Project Title	Improvements to Public Realm to Bridge Street and lands to the rear and side of The Grain Store, John's Street, New Ross, Co. Wexford
Document Title	Engineering Response to An Coimisiún Pleanála (ACP) Technical Queries
Client	Wexford County Council
File No.	J08_DRPL_020
Author	Peter Brunner
Checked by:	Tom Culligan
Date	29 September 2026
Revision	P1

This report addresses the queries raised by An Coimisiún Pleanála in regard to the proposed improvements to Public Realm to Bridge Street and lands to the rear and side of The Grain Store, John's Street, New Ross, Wexford.

01 Site Layout Plan (Entire Site) As Proposed
Scale: 1:200

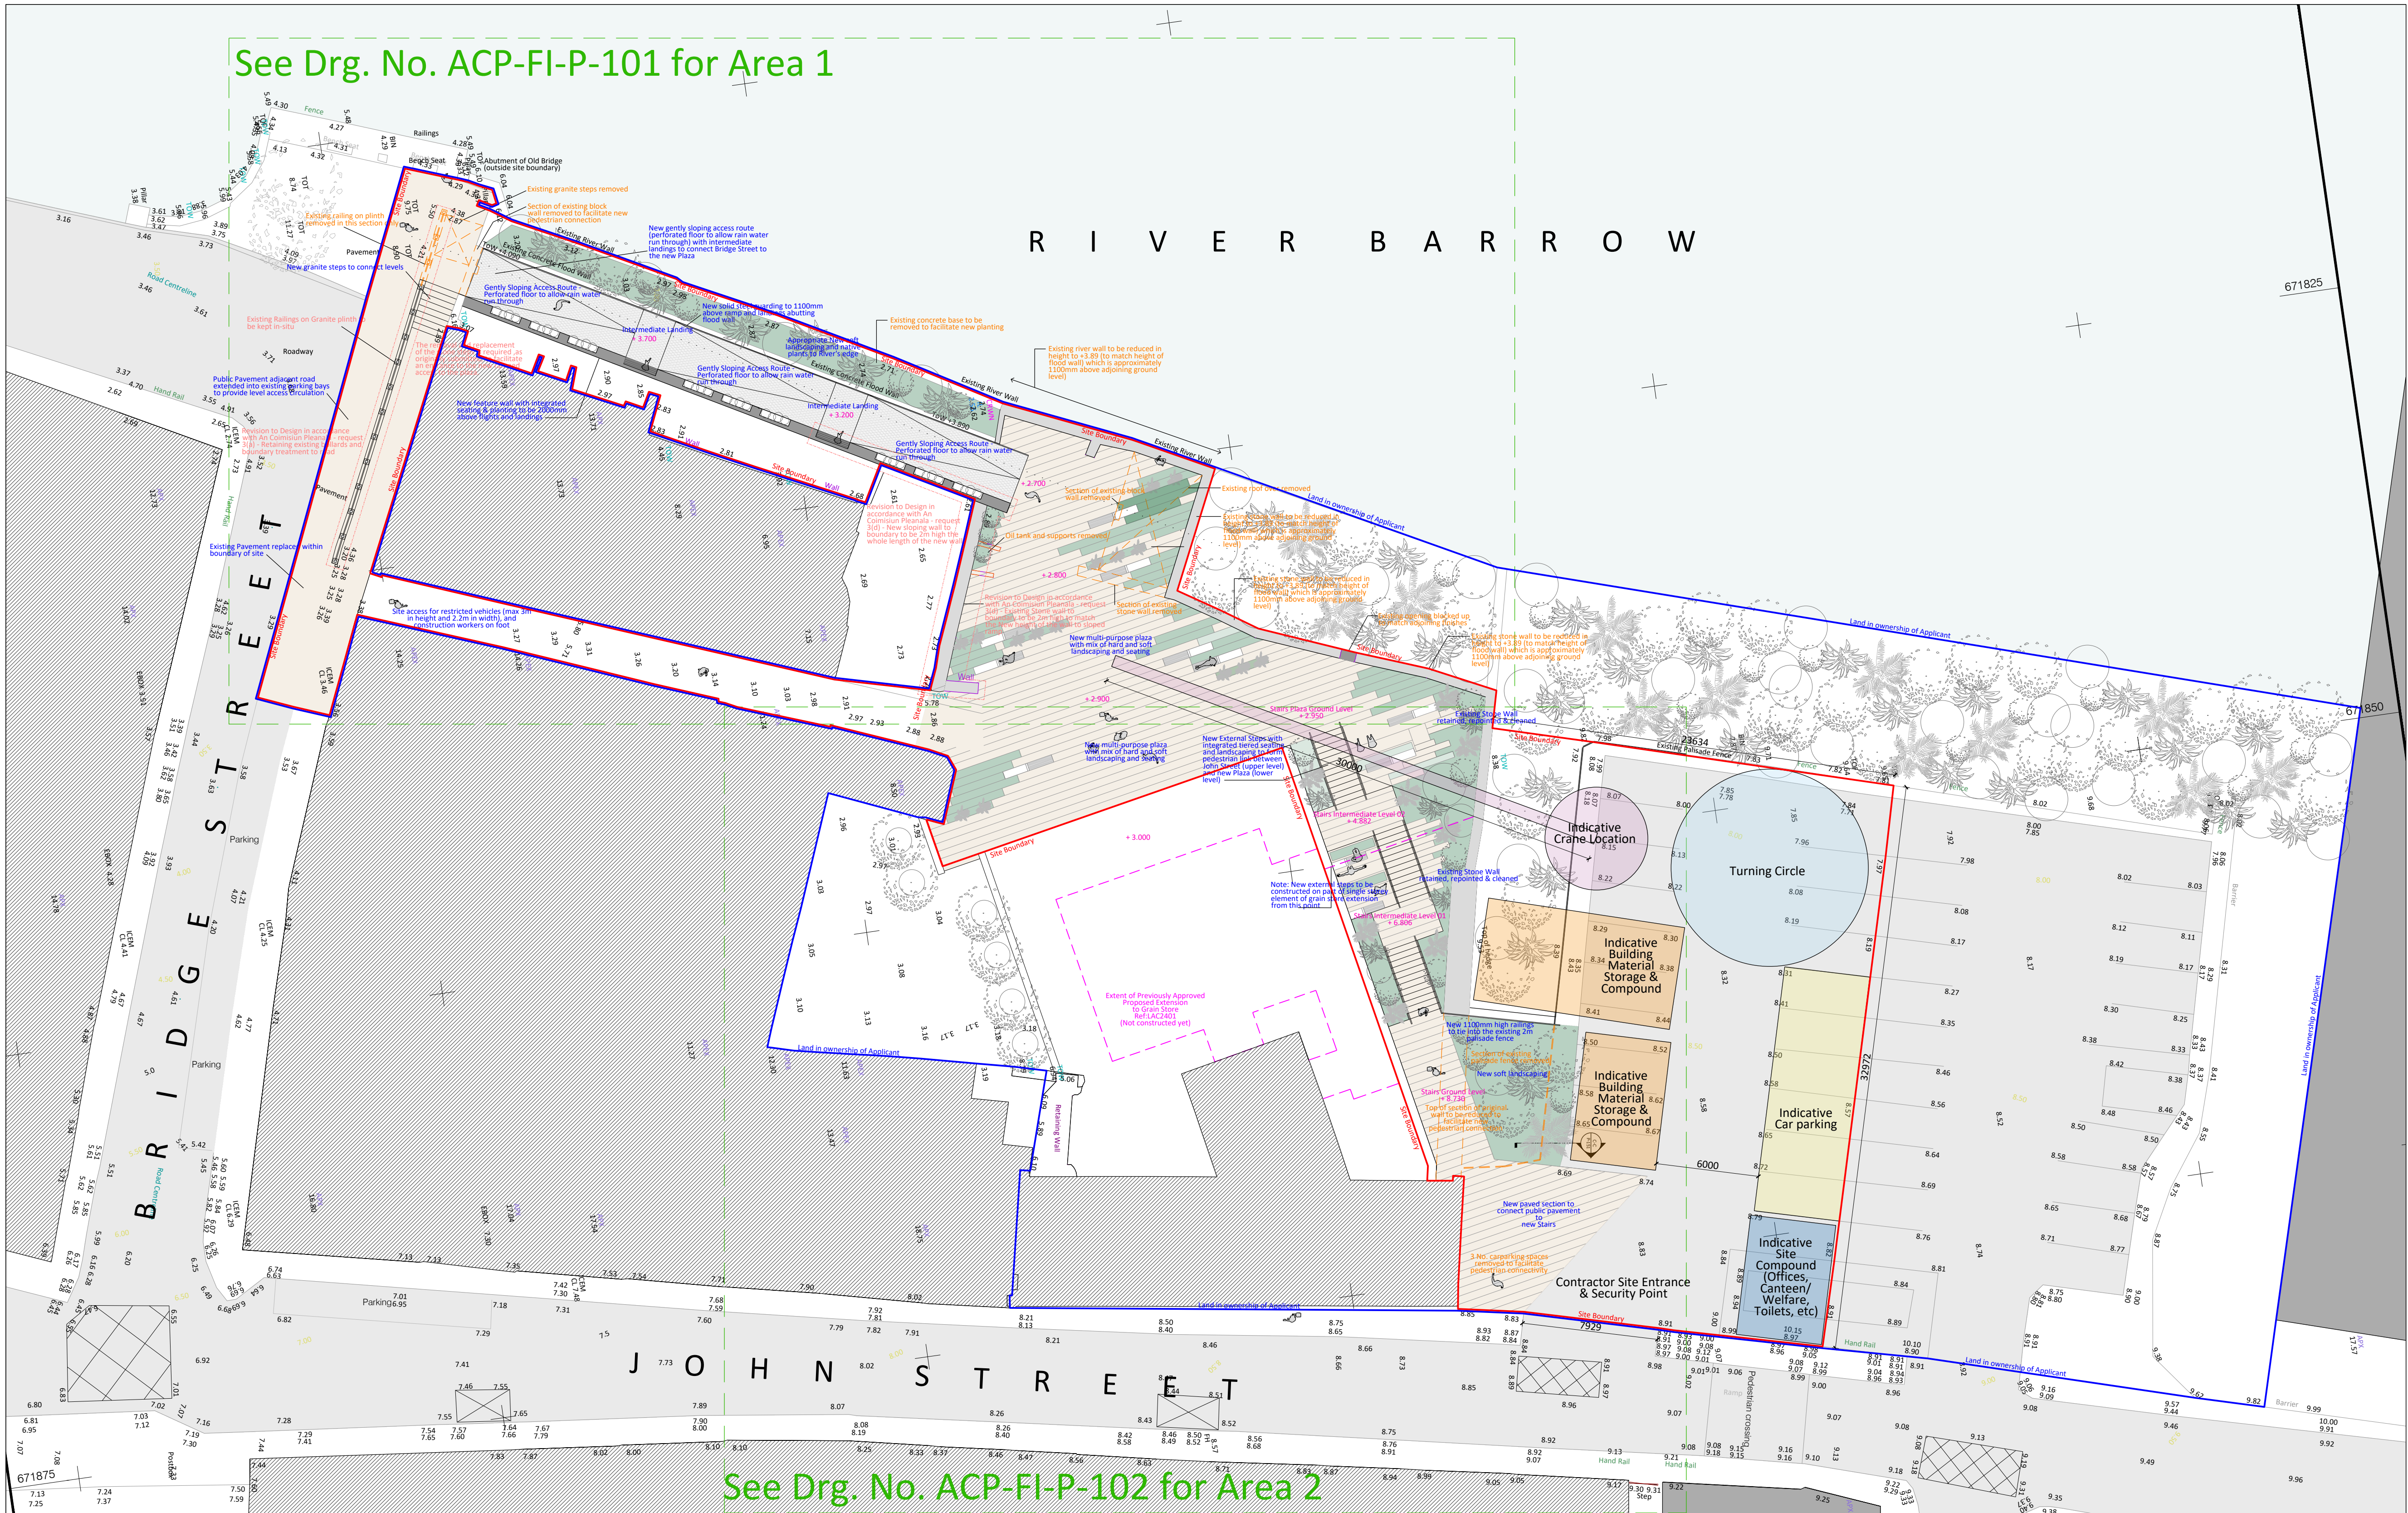
ACP Query: In relation to the Bridge Street pedestrian access ramp abutting No. 2 Bridge Street (Rogers Dental), ACP requires an existing surface water drainage plan, details of any pipes/manholes to be retained or removed, and precise engineering details on how any existing manholes beneath the proposed ramp will remain accessible for maintenance without requiring structural demolition of the ramp.

BCE has coordinated directly with ODKM Architects regarding the revised drawings. The proposed pedestrian ramp is designed as a gently sloping access route with a perforated floor structured as a suspended lightweight galvanized steel frame on slender steel posts (as detailed on ODKM Drawings 19-104-ACP-FI-P-100 and P-101 and BCE J08-P-10). It is not a solid concrete ramp. We address the specific drainage and access requirements as follows:

- **Non-Destructive Maintenance Access (S20, S21, S22):** The proposed ramp alignment directly overlies BCE manholes S20, S21, and S22. To ensure Wexford County Council maintenance crews can access these structures at all times without structural demolition or ramp closure, ODKM Architects will integrate flush-mounted, removable structural floor access panels directly into the ramp's timber/composite perforated decking. These lightweight, slip-resistant composite panels can be easily lifted to expose the underlying standard manhole covers for routine rodding, jetting, or CCTV surveys.
